From: Planning
Subject: FW: 3/2023.0849

3/2023/0849

Further to consultation with all members of the parish council, the following objections have been raised: -

SHEET: PROPOSED SITE PLAN

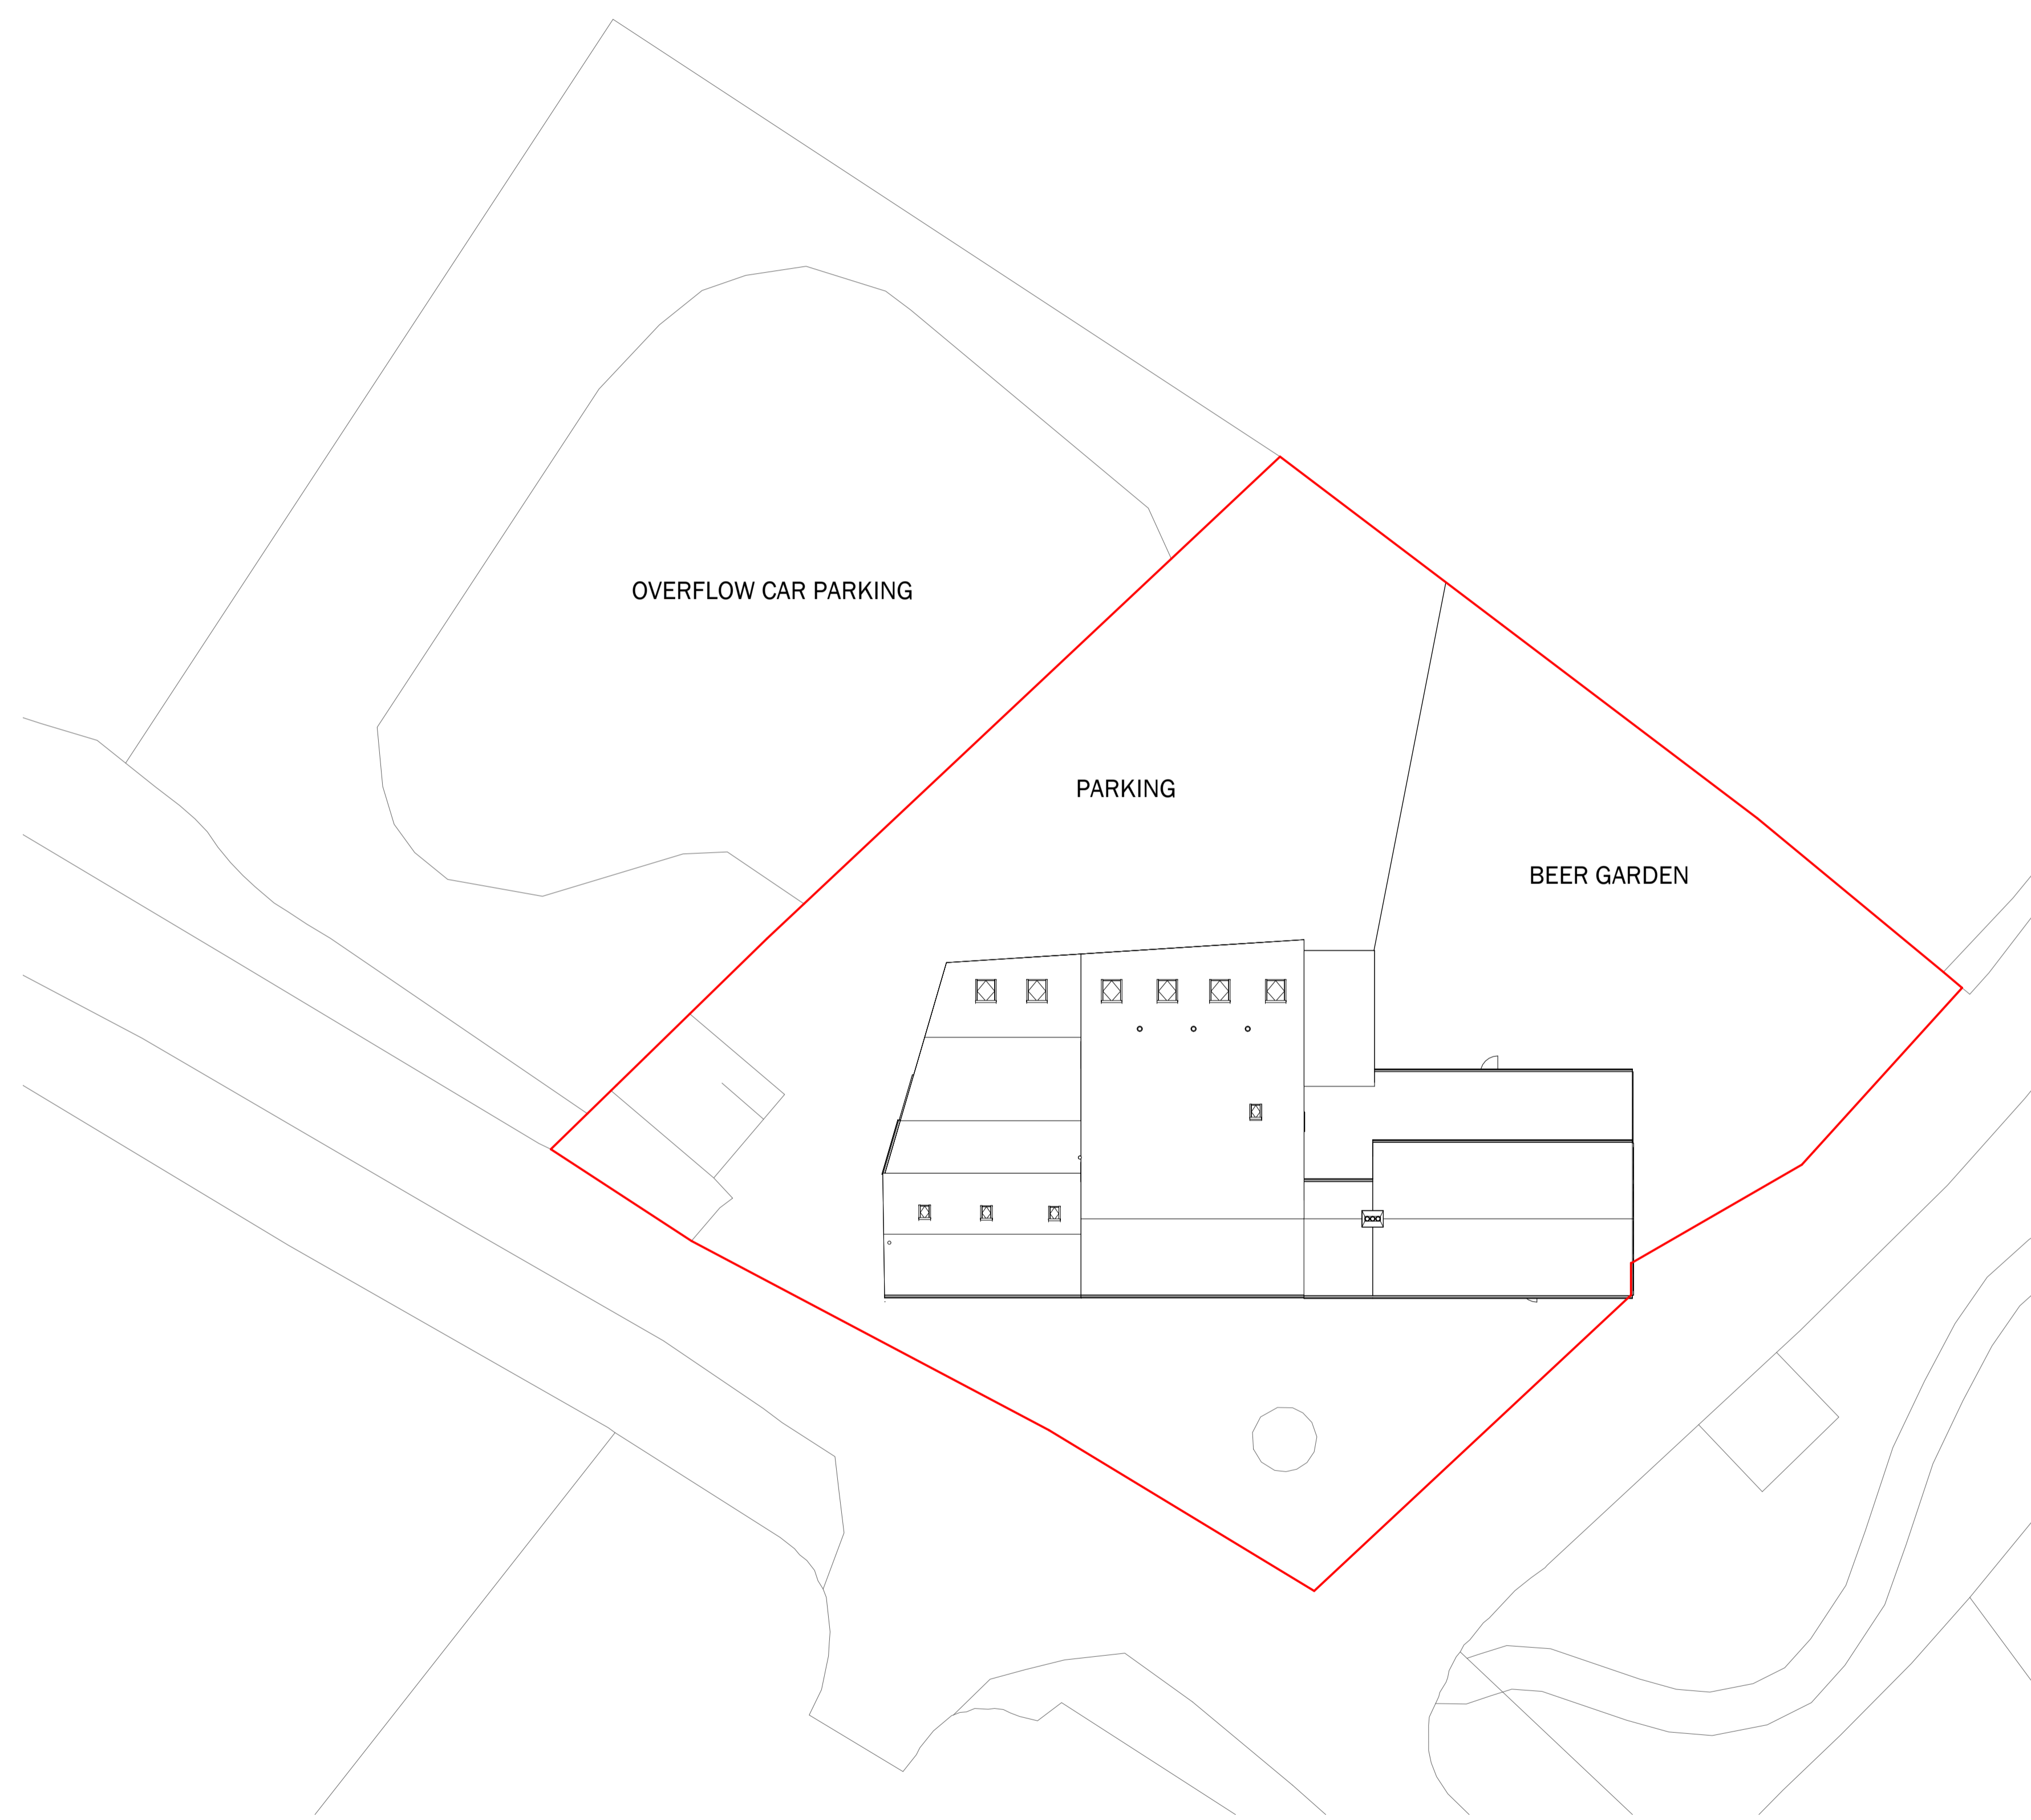
- On viewing the plans, it looks as if the piece of pastureland which was pegged out during covid adjacent to the has become over spill car park? If this is the case has there been an application for change of use for this.

4.0 ACCESSIBILITY 4.1 The only vehicular and pedestrian entrance to the site is via Old Langho Road. The location of the entrance of the site will remain. The proposal does not affect the existing car parking spaces, two being accessible as shown on the site plan. The visibility splays from the site onto Old Langho road are excellent with no obstructions.

Concerns were raised about the 4.0 Accessibility: -

1. Most evenings and especially at the weekend there are cars parked, even though they often look more like they are abandoned, around the pub and on the roads and verges, often 100+ yards either side so there are already quite severe issues with parking and traffic, if this application would make the issue worse than it already is
2. The other concern I have is the road directly outside the Black Bull has a 60mph limit when travelling from the direction of Dinckley up to the pub where it drops to 40mph.
